CITY OF PORTLAND BUILDING PERMIT

PERMIT ID: 2013-00838

has permission to **Erect 120' x 60' tent, set up Friday, June 21, 2013 and breakdown Saturday, June 22, 2013.for 2013 Hotwing Challenge**

HOT WING COOK-OFF TENT CHALLENGE

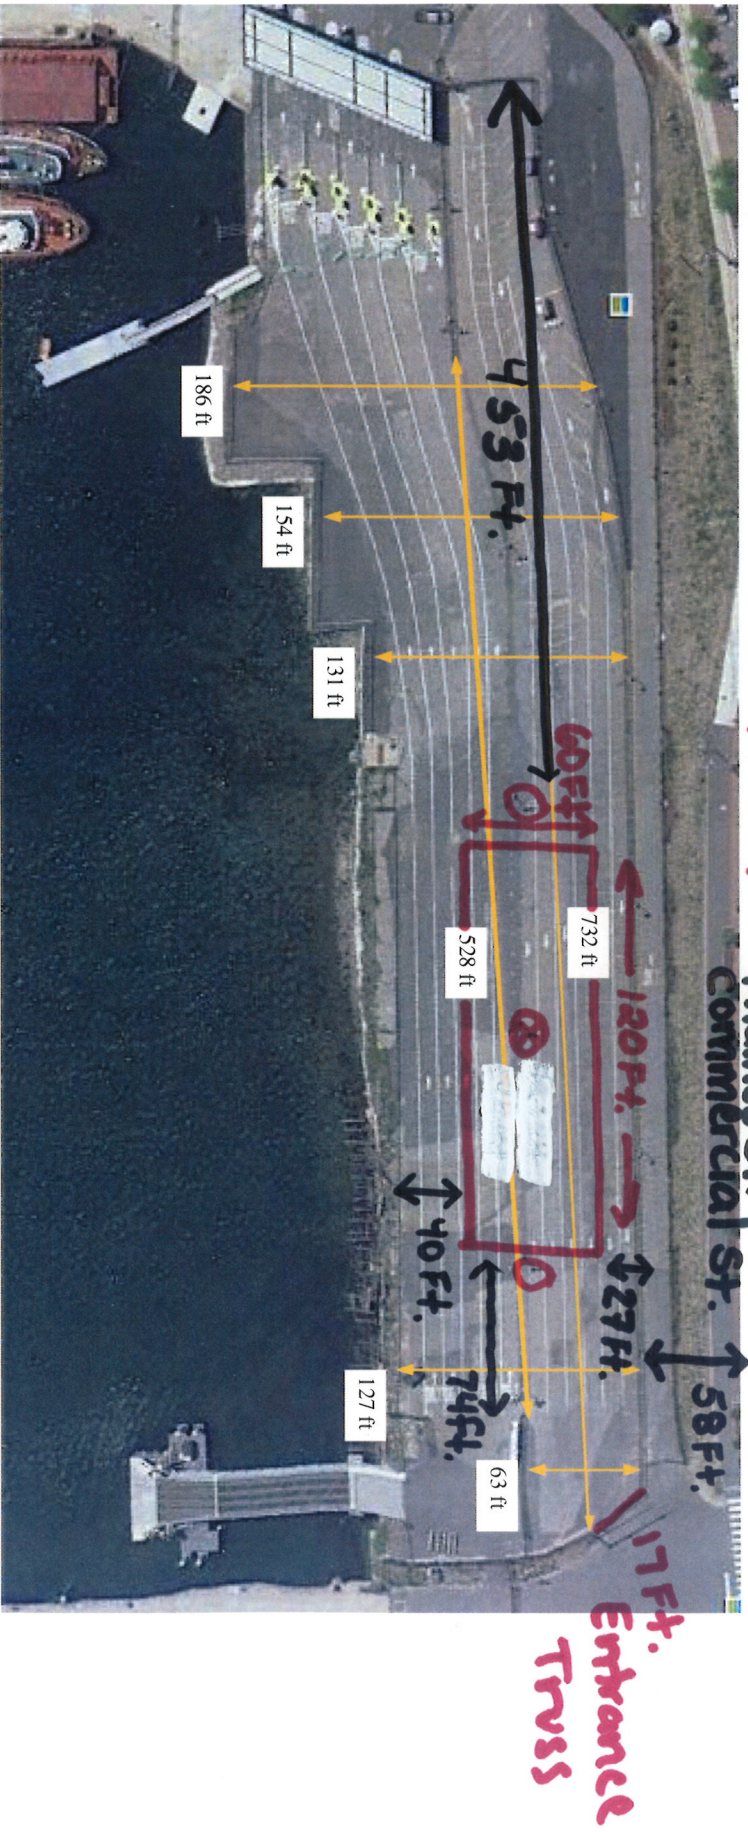
1) The cooking equipment arrangement and type shall be evaluated at the inspection.				
2) The fire department shall inspect the premise prior to the event.

3) Fire extinguishers will be required per NFPA 10.				
4) A minimum 1 radio equipped firefighter shall be hired.				
5) A minimum of __ trained crowd managers shall be provided and on duty inside of the occupied tents during the event.

6) EXITs				
a.The main entrance shall have minimum clear width of 10 feet.				
B.The divider in the main tent shall maintain an exit opening of 6 feet.				
C.A main corridor for the main tent shall be maintained a minimum of 50 inches. Where a chair is placed between a table and the corridor the measurement shall be made from the table and add 19 inches for each chair (ie. Chair at both sides 38" + 50"= 88").				
D.An exit from the main tent to the outside directly across from the main entrance shall be provided. Minimum clear width shall be 6 feet.				
E.The auction tent shall have 2 exits perpendicular from the main tent. Minimum clear width shall be 36".				
F.The catering tent shall have one additional exit across from the main tent. Minimum clear width shall be 36".

7) Emergency lighting and approved illuminated EXIT signs are required for events held outside of day light hours. A back up generator with transfer switch shall meet this requirement if the following is met:				
a.All lighting is powered from the generator circuit.				
B.The lighting illuminates the face of the EXIT signs.				
C.An auto transfer and start shall be provided or dedicated staff shall be provided for that purpose.

8) All tents shall meet the flame propagation performance criteria contained in NFPA 701. A certificate or other evidence of acceptance by an organization acceptable to the AHJ shall serve as evidence that the tent fabric materials have the required flame propagation performance.

9) Cooking within the tents has not been reviewed and approved.				
10 Fuel-fired heating equipment and propane tanks shall be installed outside of the tents and not with 5 feet of the tents or an exit discharge.				
11 If the sides of the tents are to be enclosed at least two remotely located and marked exits shall be provided.				
12 Tents shall have an approved fire resistant rating and maintain 10' between stake lines. No smoking or open flame allowed within 10'. Provide at least one 2A:10 BC fire extinguisher.
